Development Facilitation Team (DFT) – Review Comments

Project No: PR-2021-005151 Date: 08/09/2023 Agenda Item: #1 & 2 Zone Atlas Page: A-12

Legal Description: TRACT D-1 PLAT OF TRACTS D-1, E-1, AMAFCA BLACK ARROYO CHANNEL ROW PARADISE HEIGHTS

Application For: SD-2023-00124-PRELIMINARY PLAT (DHO)

Plat of
Tracts D-1-A, D-1-B, D-1-C and D-1-D
Paradise Heights, Unit 1
 Section 1, Township 11 North, Range 2 East, N.M.P.M.
 Albuquerque, Bernalillo County, New Mexico
 October 2022

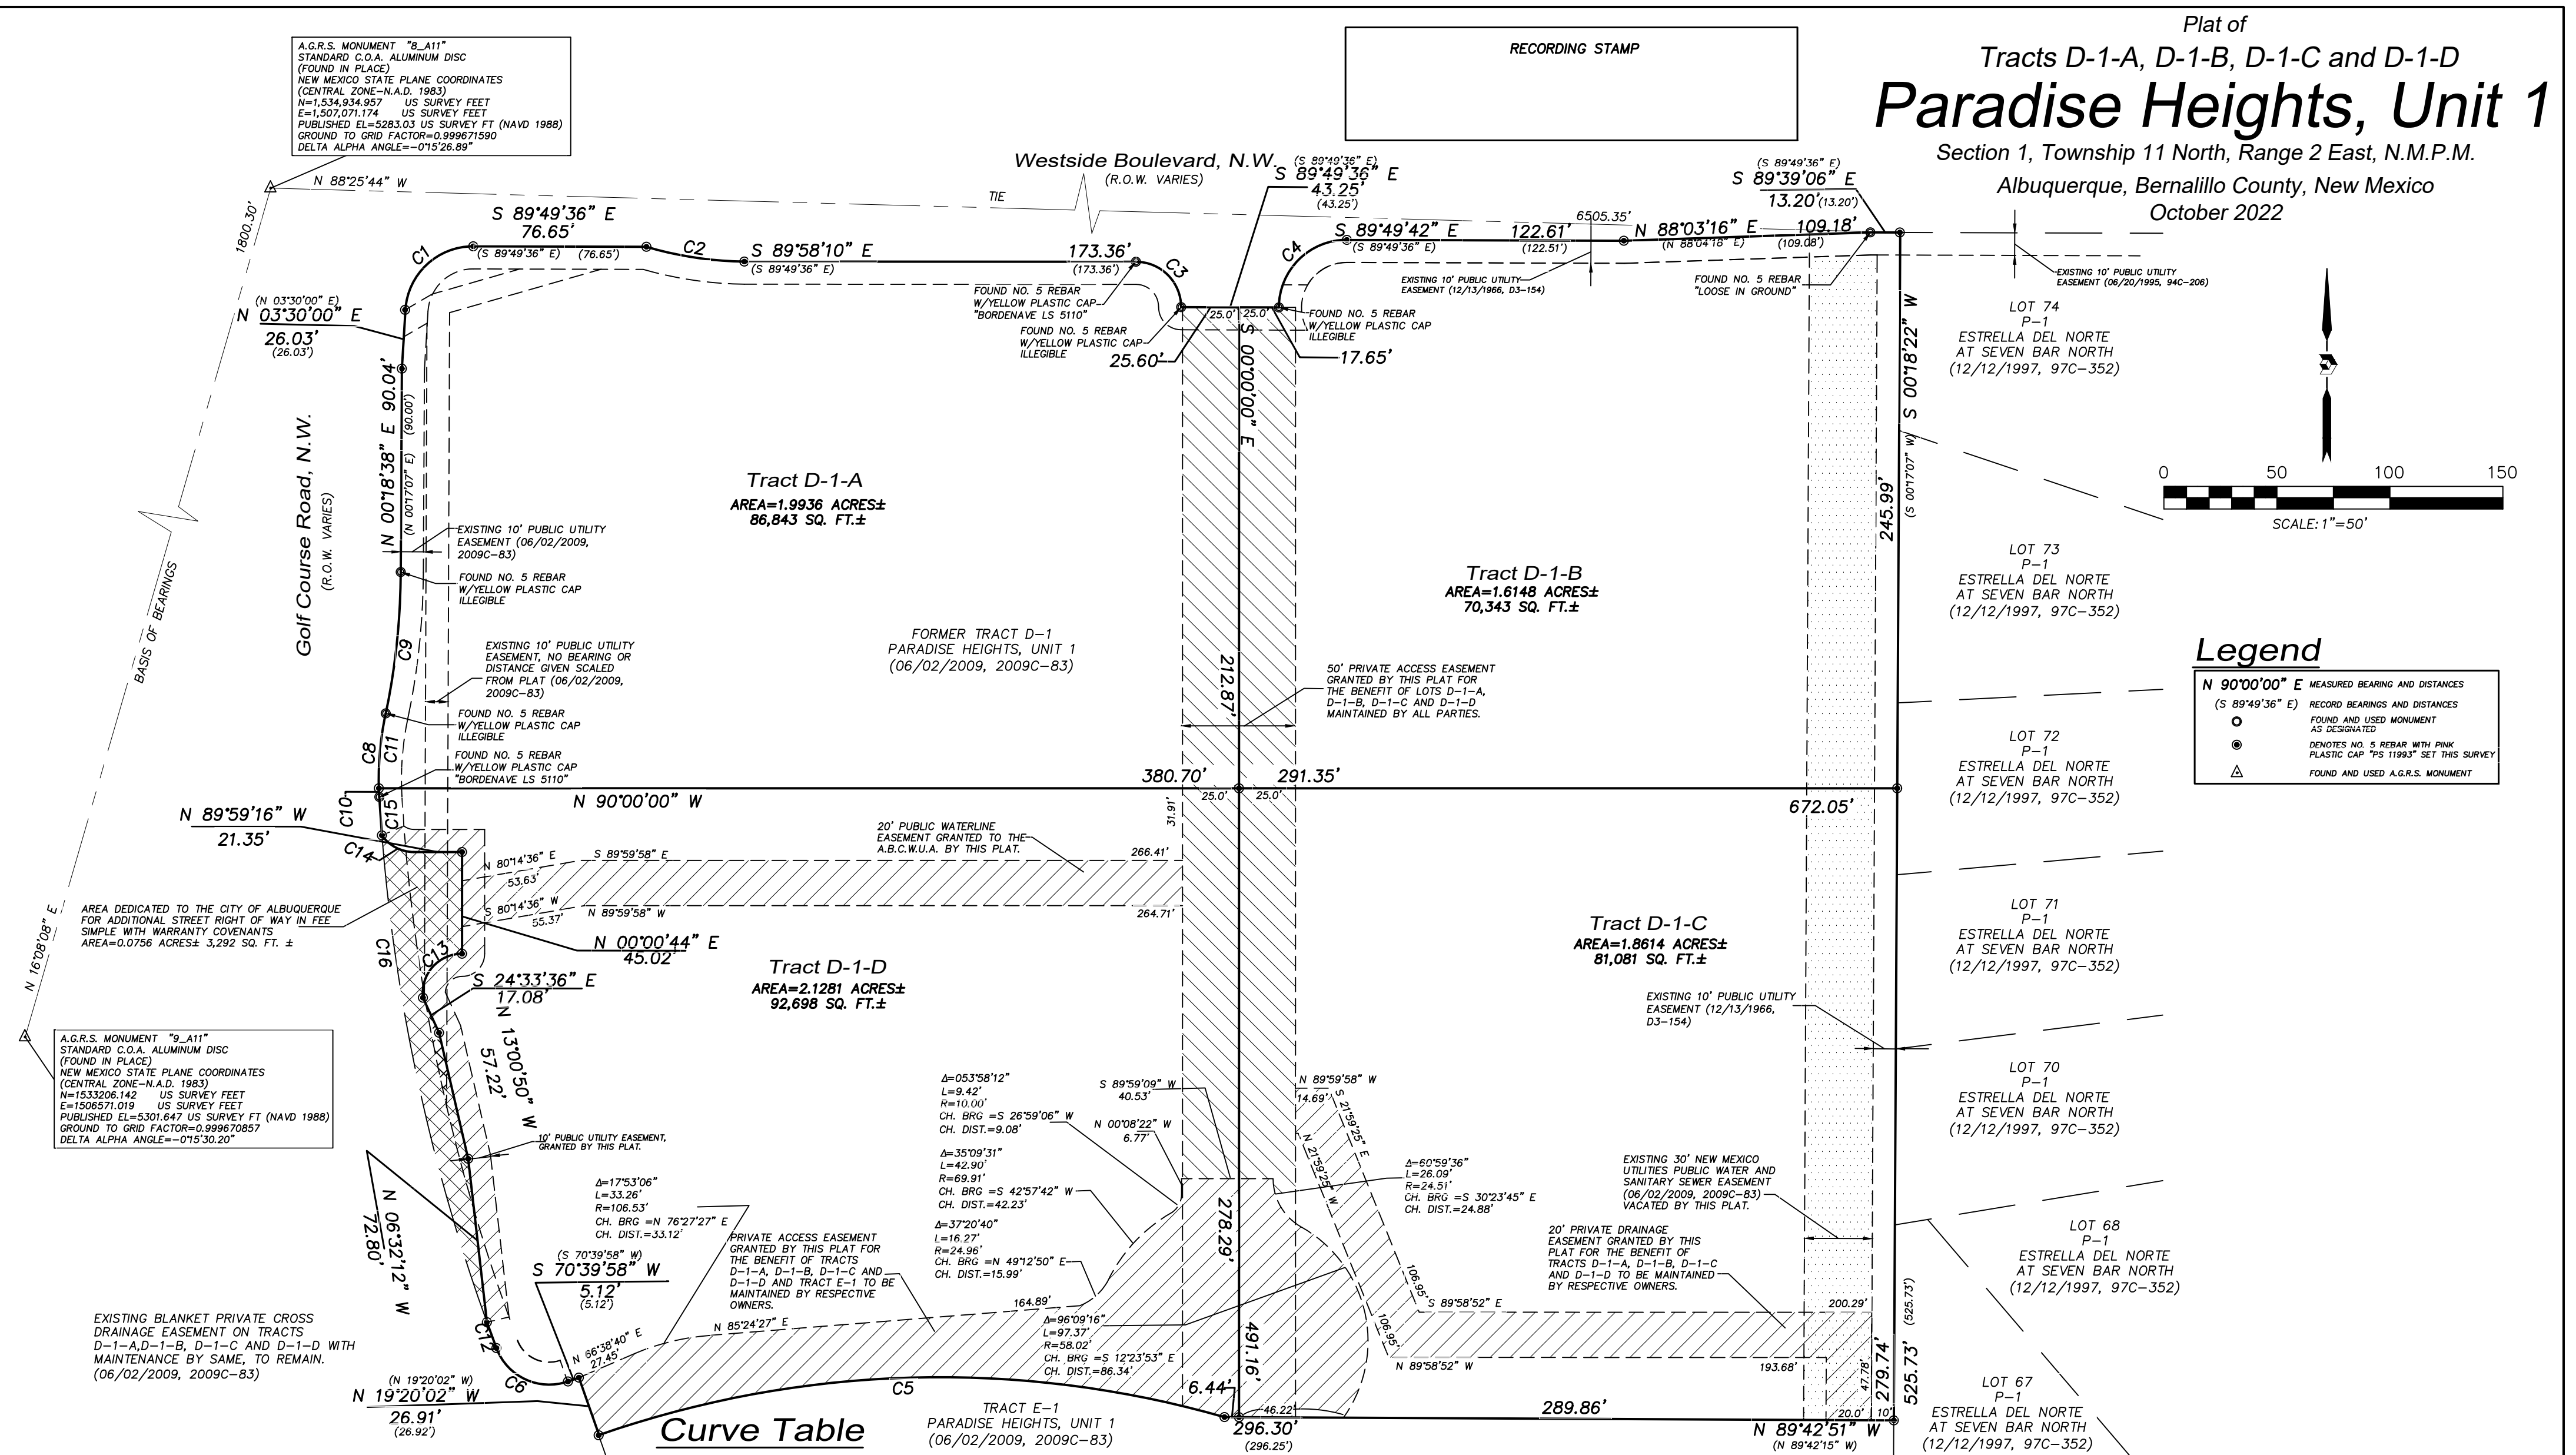
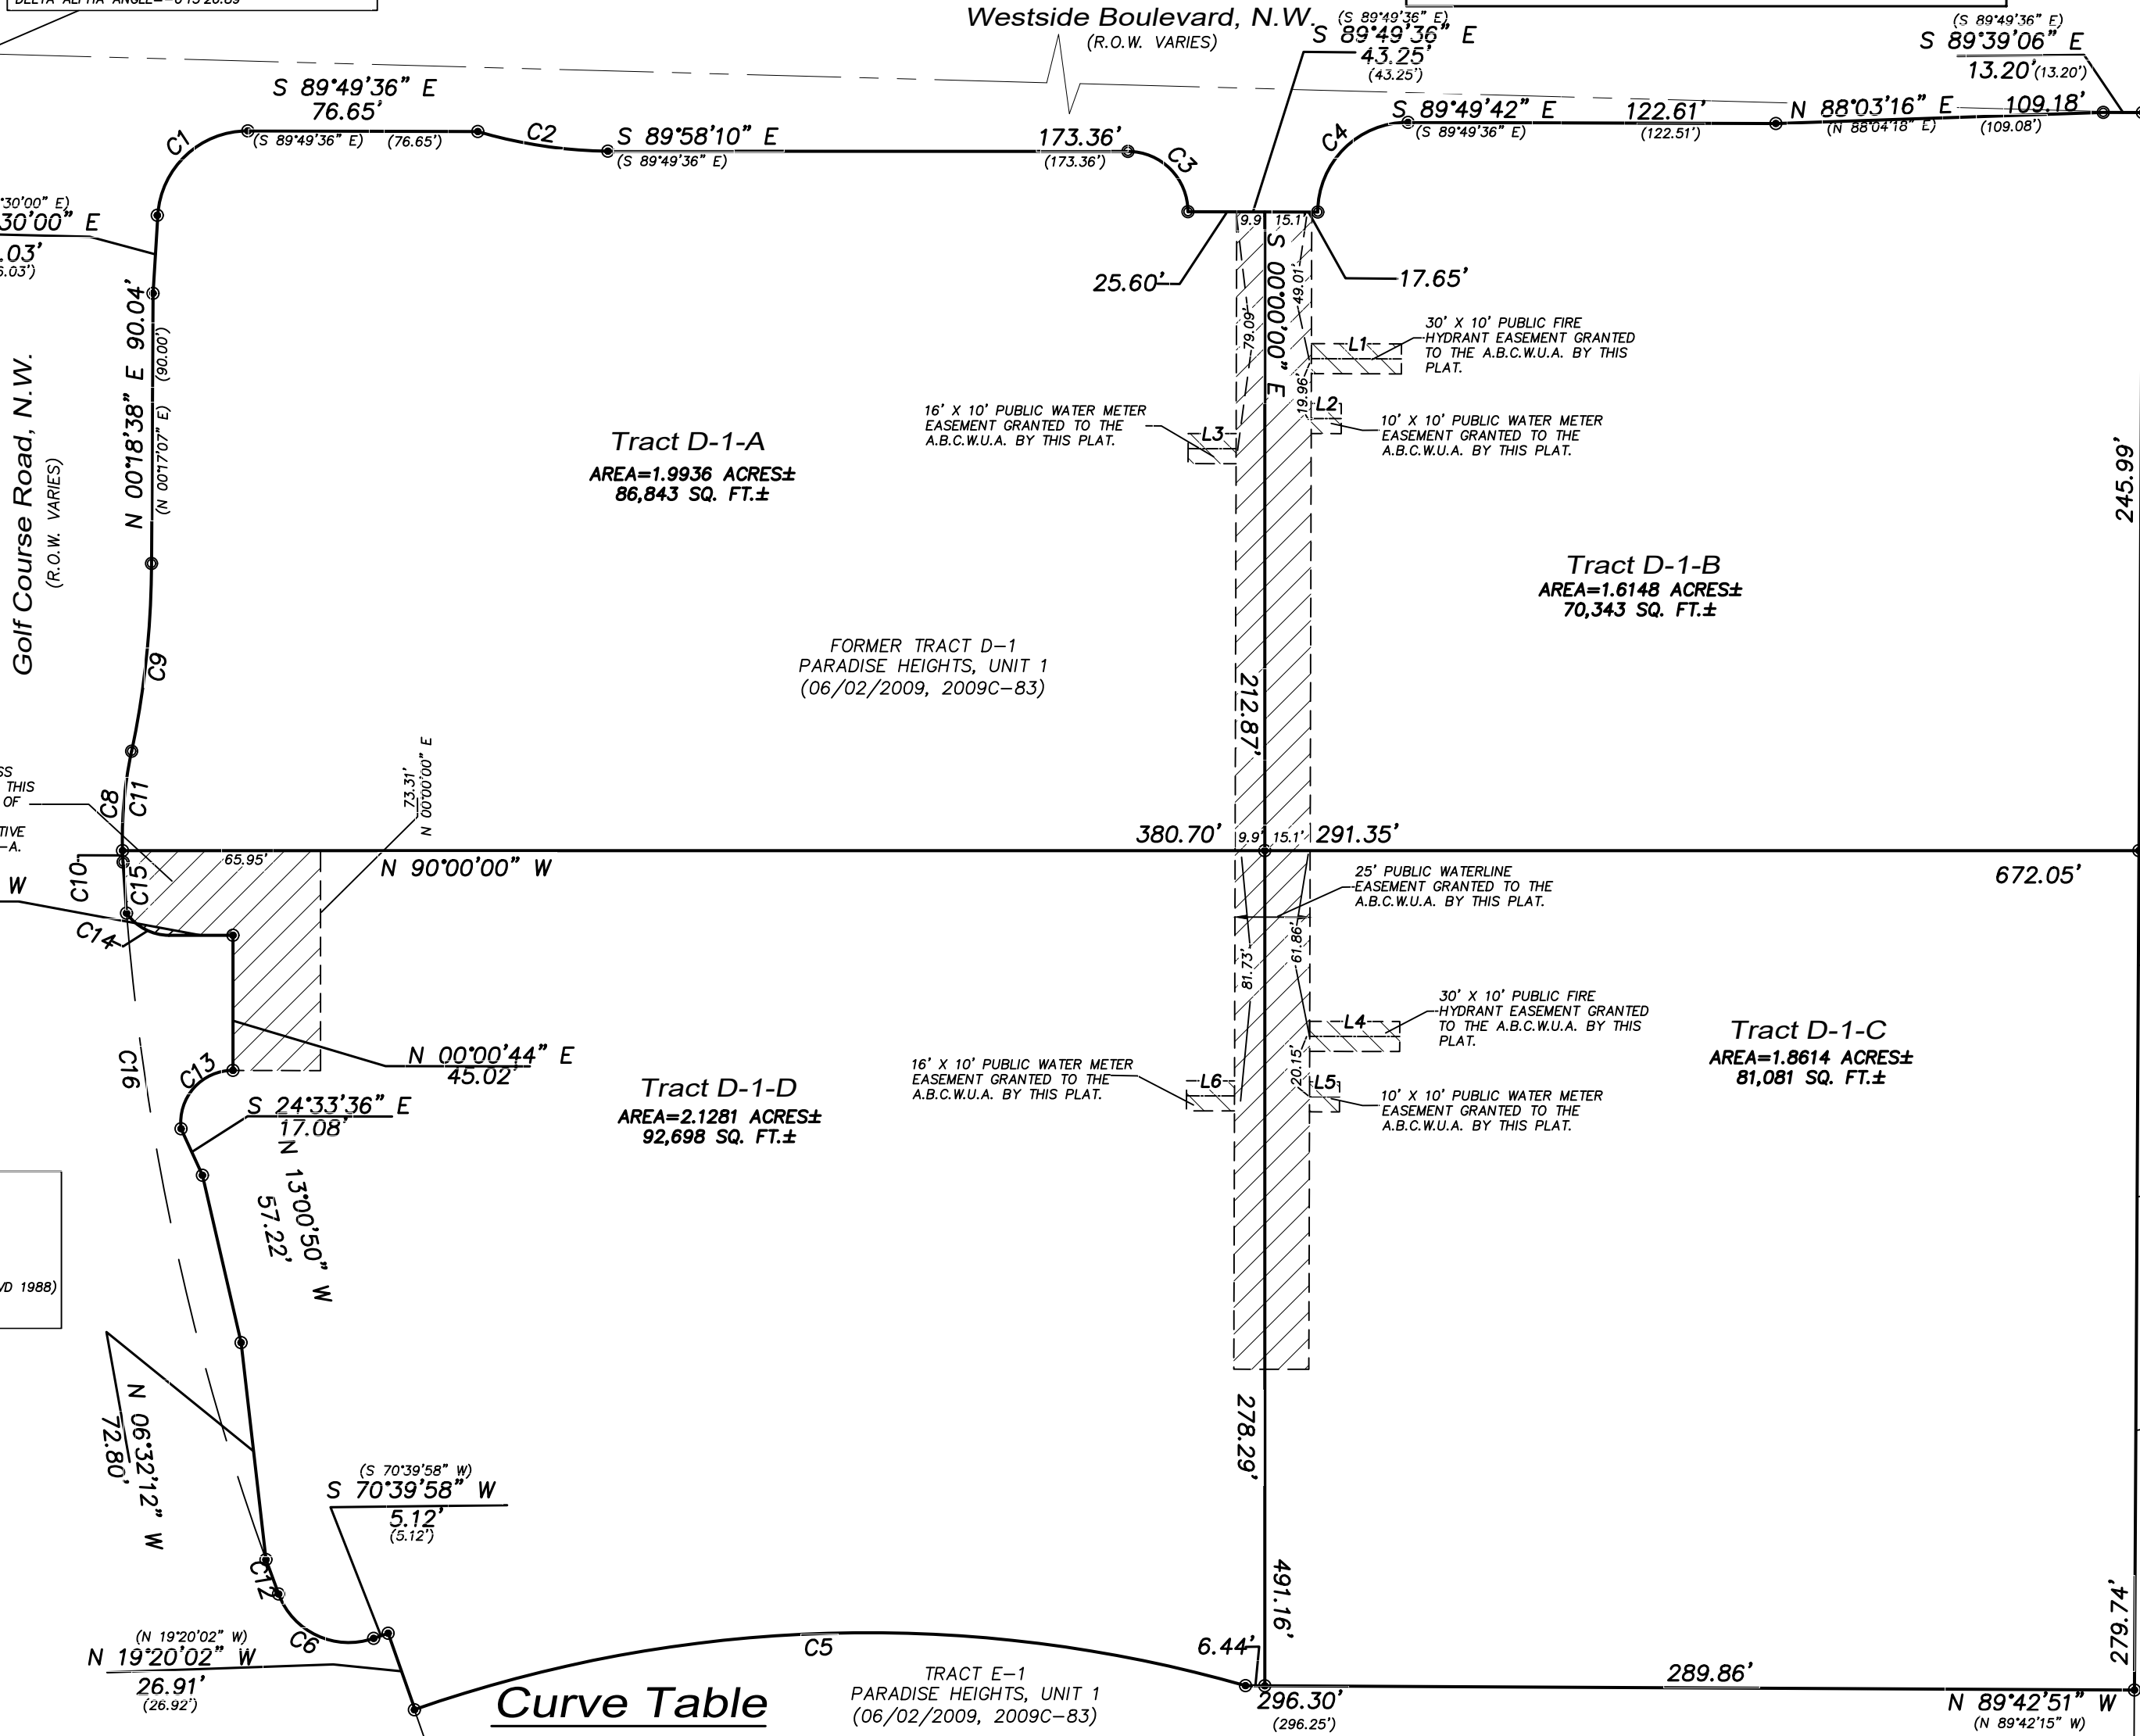
- a. Add the following note on the plat when easements are being granted for public water and/or public sanitary sewer infrastructure.

- b. Please provide a composite of the Water Authority easements being granted to clearly show how the site will be developed regarding water and sanitary sewer infrastructure.
- c. For the 25’ public water and public sanitary sewer easement, please clearly separate the easement as bisected by the North/South property line. The easement shows 10’ on the west portion of the property line and 15’ on the east portion of the property line but it should be noted that the easement is separate on respective tracts. (e.g. a 10’ public water and public sanitary sewer easement and a 15’ public water and public sanitary sewer easement.)
